Please ask for: Ms Iqraa Malik
Email: iqraa.malik@terraquest.co.uk
Telephone: 0121 234 1390
Our Ref: R/258/21/HH
Your Ref:
Date: 14th October 2021

Application for Planning Permission for Works or Extension to a Dwelling

Development: Erection of single storey rear extension following demolition of existing rear extension

Location: Mallon Dene 47 Mallon Dene Rustington BN16 2JP

P05 Existing Elevations

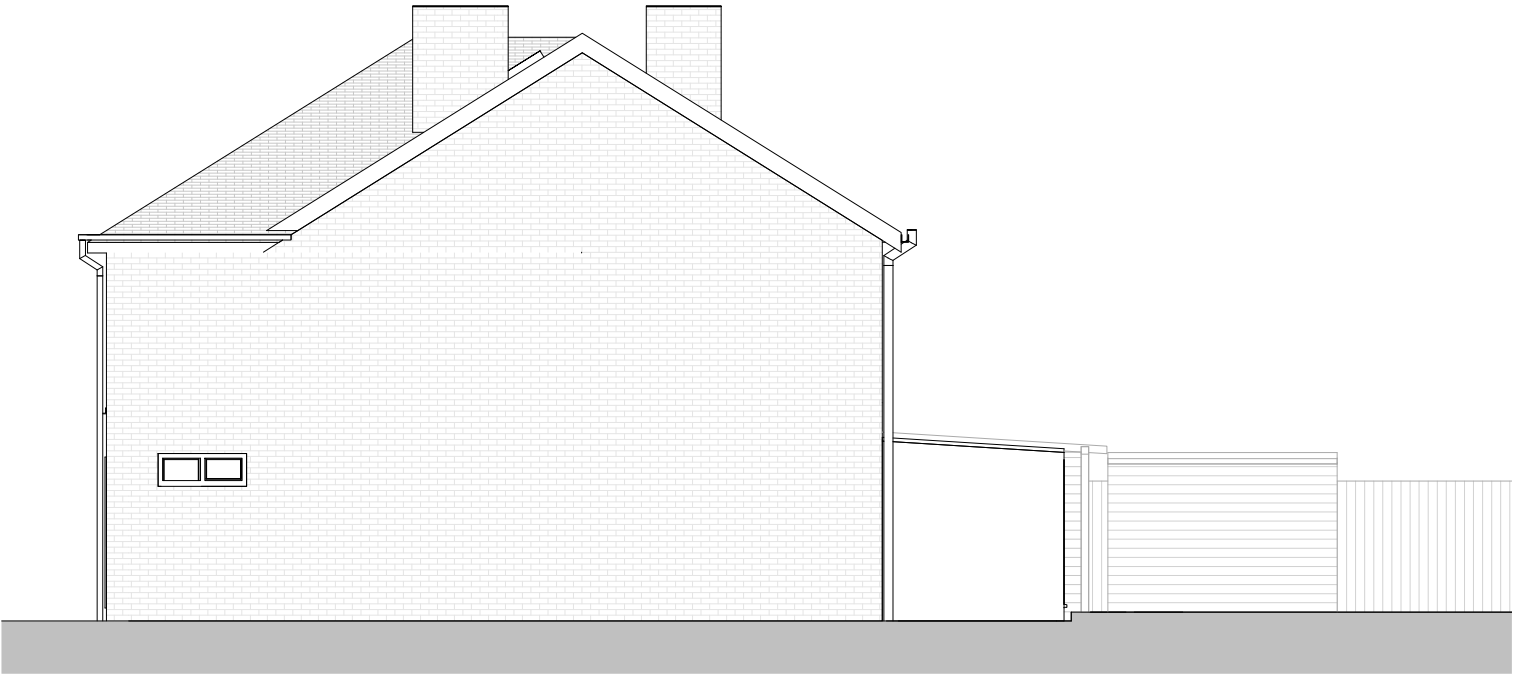
The garage shown on the existing/proposed south elevations are inconsistent with the existing/proposed ground floor plans
